## PRE-APPLICATION RESPONSES

**Pre-Application Response (ABOVE)**  
78364/PRC/2023/185

**Conex House, 148 FIELD END ROAD**

*'Demolition of existing building and redevelopment of site to provide a part 3, part 4 storey residential building.'*

Proposed: Ground Floor Site Plan

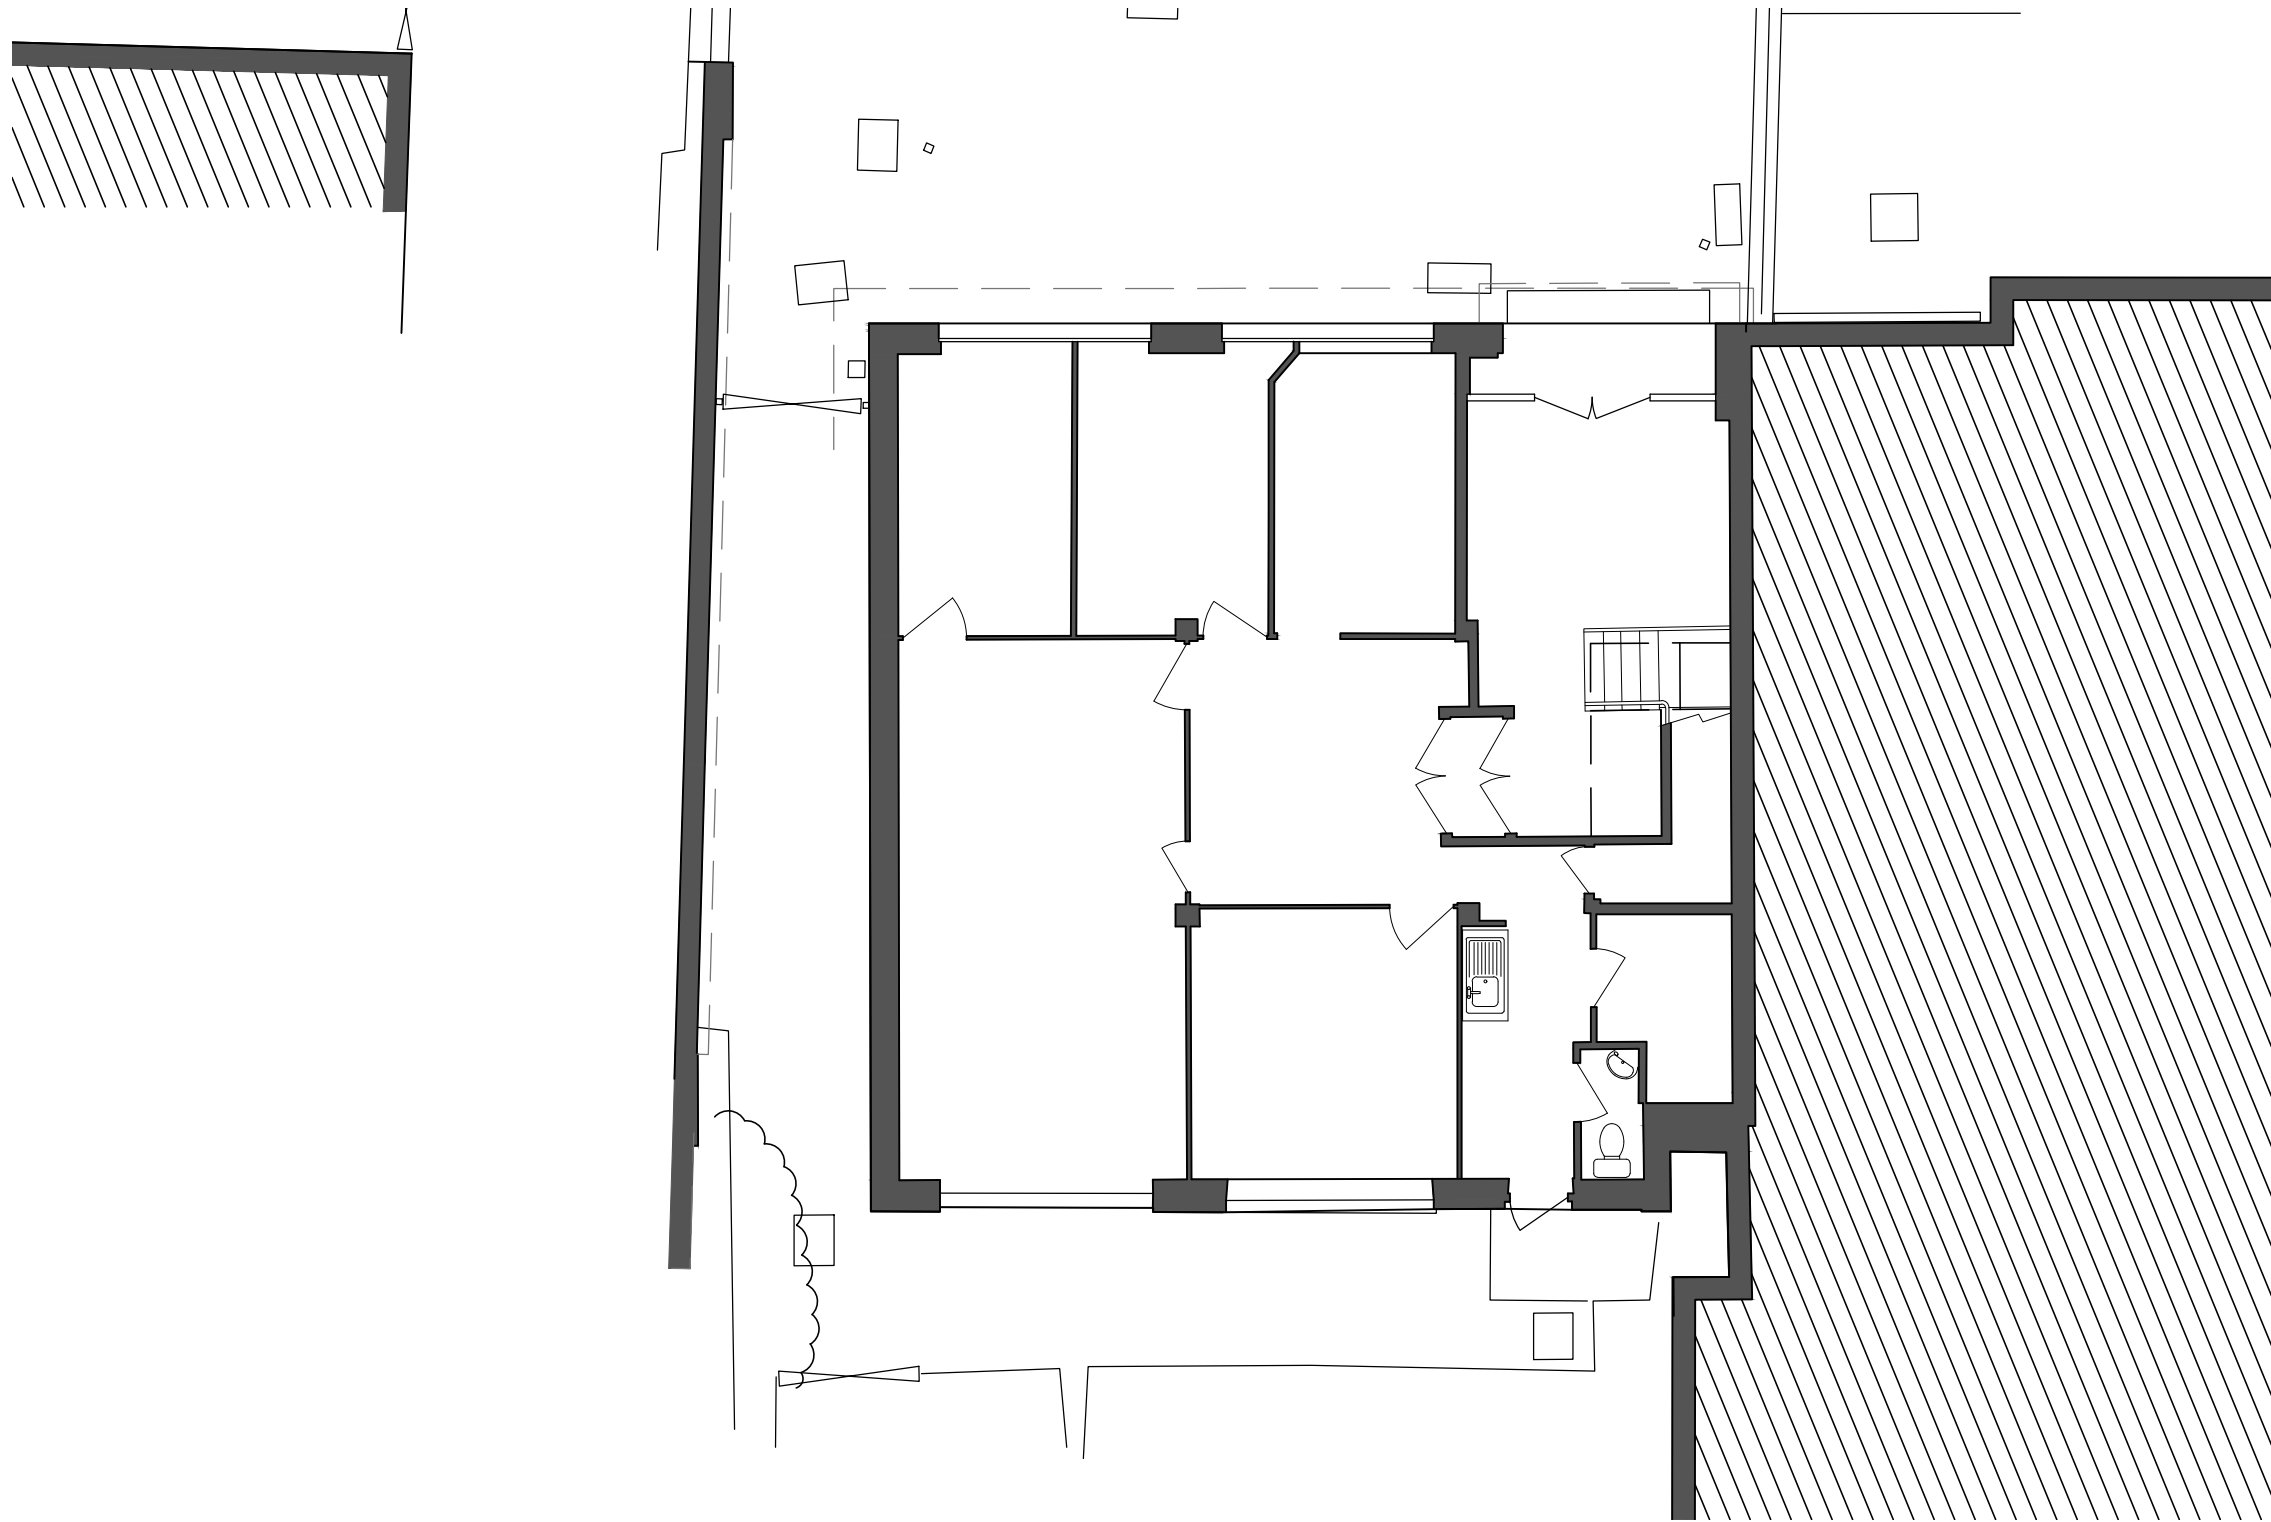
- The proposed quantum of cycle spaces would be policy compliant.
- However, the applicant is advised that the proposed two-tier cycle storage systems are typically not supported by officers and are considered unsuitable for new residential developments, as many of these styles are difficult to use when bicycles are fitted with baskets and child seats, and usually require lifting. This can be difficult for the less able or those with heavy bicycles. Therefore, the applicant is advised to review this element of the proposed scheme and revise the rear cycle storage to Sheffield stands or similar.

- Additionally, officers remain to be convinced that the proposed siting of the cycle stores to the front in proximity to the car parking spaces would be practical, specifically when the car parking spaces are occupied by vehicles. The layout should be reconfigured to allow for unimpeded transfer of cycles to/from the store in order to promote usage amongst future residents.
- Any formal planning application would be expected to include design and materiality details of bicycle storage in the form of a dedicated enclosure(s).

- In order to conform to the Council's 'waste collection' maximum distance collection parameter of 10m i.e. distance from a refuse vehicle to the point of collection, arrangements should ensure that waste bin storage is positioned at a collection point within this set distance. In addition, the maximum carrying distance from each flat should not exceed 30m.
- A secure and covered bin store is shown on the submitted site plan to be positioned along the building's northern boundary and will provide space for 2no. 660L Eurobins, with bins split into one for recycling and one for general waste. This is generally considered acceptable.
- Any forthcoming formal planning application should specify capacity and materiality details of the proposed refuse/recycling enclosure and clearly identify this on plans.

- Two-tier cycle storage has been removed with 12 Sheffield cycle parking spaces to be provided to the front of site, please see Landscaping scheme for layout and examples of cycle shelters.

- The landscaping scheme that has been submitted along side the design and access statement shows the proposal of 12 sheffield cycle stores and the easy access to and from the cycle store to encourage use.
- Refer to landscaping scheme and drawing 0562-PL-210-0 for cycle store locations and bespoke examples.
- Refer to landscaping scheme and drawing 0562-PL-210-0, for refuse store location and materiality notation.

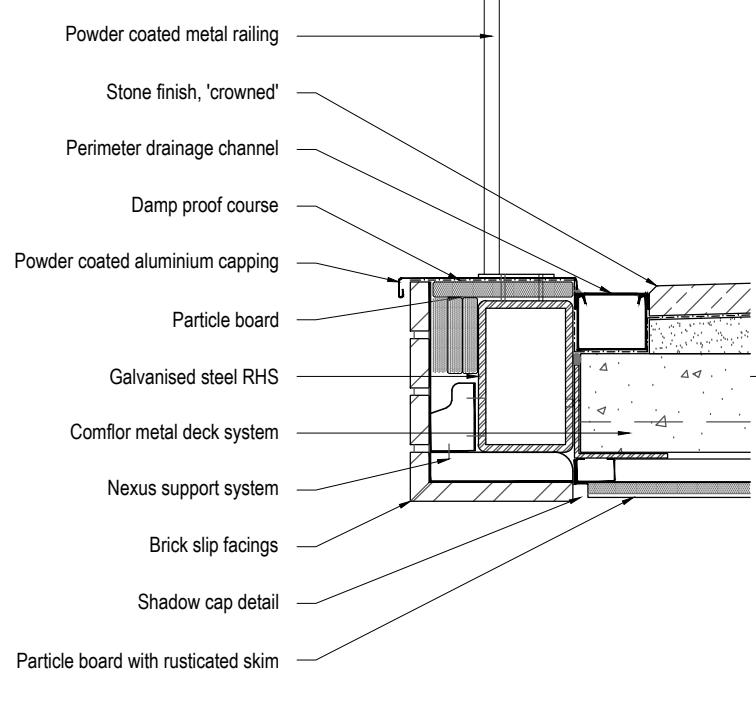
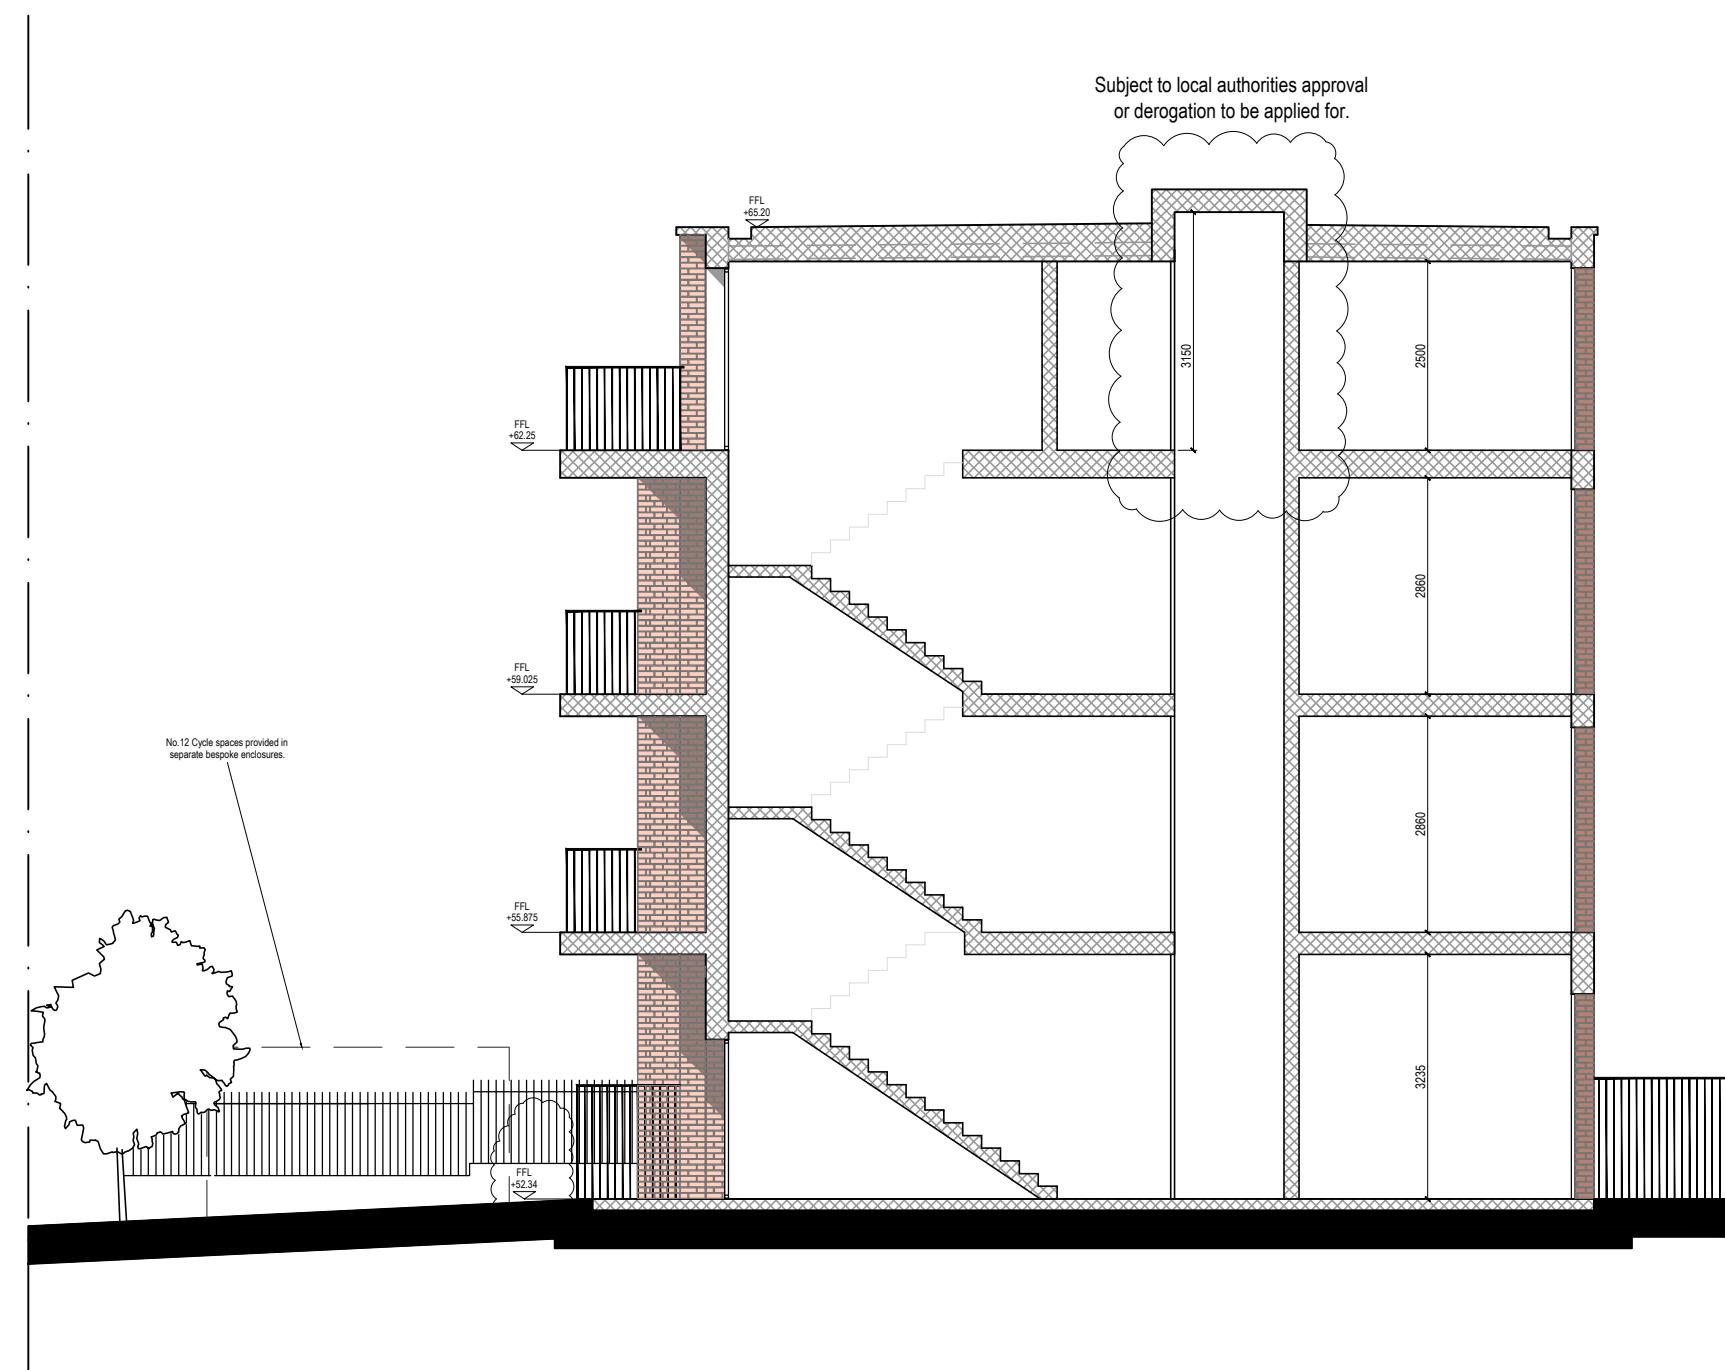
- The proposed front elevation (including rooftop treatment) is not supported.
- Excessive amounts of metal cladding would not be supported as it would not be in keeping with the valued features along Field End Road and would detract from the residential character of the proposed development. There may be the need for some architectural articulation to the openings, fenestration, entrance, or some banding, subject to new proposed appearance arrangement and articulation.
- The rear elevation should follow the changes to the appearance and tie in with the character of the front elevation as far as possible.

- The applicant is strongly recommended to consider metal railings for the balconies. Glass balconies are not considered to be a valued feature in the area / along the high street and would fail to provide adequate privacy for the apartment residents.

- introducing a FOB key gateway for the undercroft alleyway to ensure it is safe and secure and avoids ASB and potential for crime.

- Metal cladding from the pre application has been omitted from the design following the development above. We have replaced this with a reduced amount of timber panelling and brick detailing (herringbone brick and soldier course) taken from local context.

- The proposal (also mentioned in material section and design precedent pages) now has black metal railings in keeping with local context.
- With the removal of the metal cladding and massing changes, brick now portrays as the primary choice of material. To generate more interest there is a proposal of brick detailing, herringbone bond pattern work and brick pillars. Further development towards brick and these design choices has led to the removal of all render on the proposal, generating a clean contemporary look.
- Refer to both drawings 0562-PL-221-0 and 0562-PL-222-0 along with the proposed material section for visual appearance notes and products.
- Refer to the proposed material section for visual appearance notes and selected products in principle.

- On the front elevation (0562-PL-221-0) a FOB key gate to the ground floor for access to the rear of the site has been proposed. (Metal Gate Lock With Back To Back Free Turning Lever ECP Keypads & Trigger Release Deadbolt.)
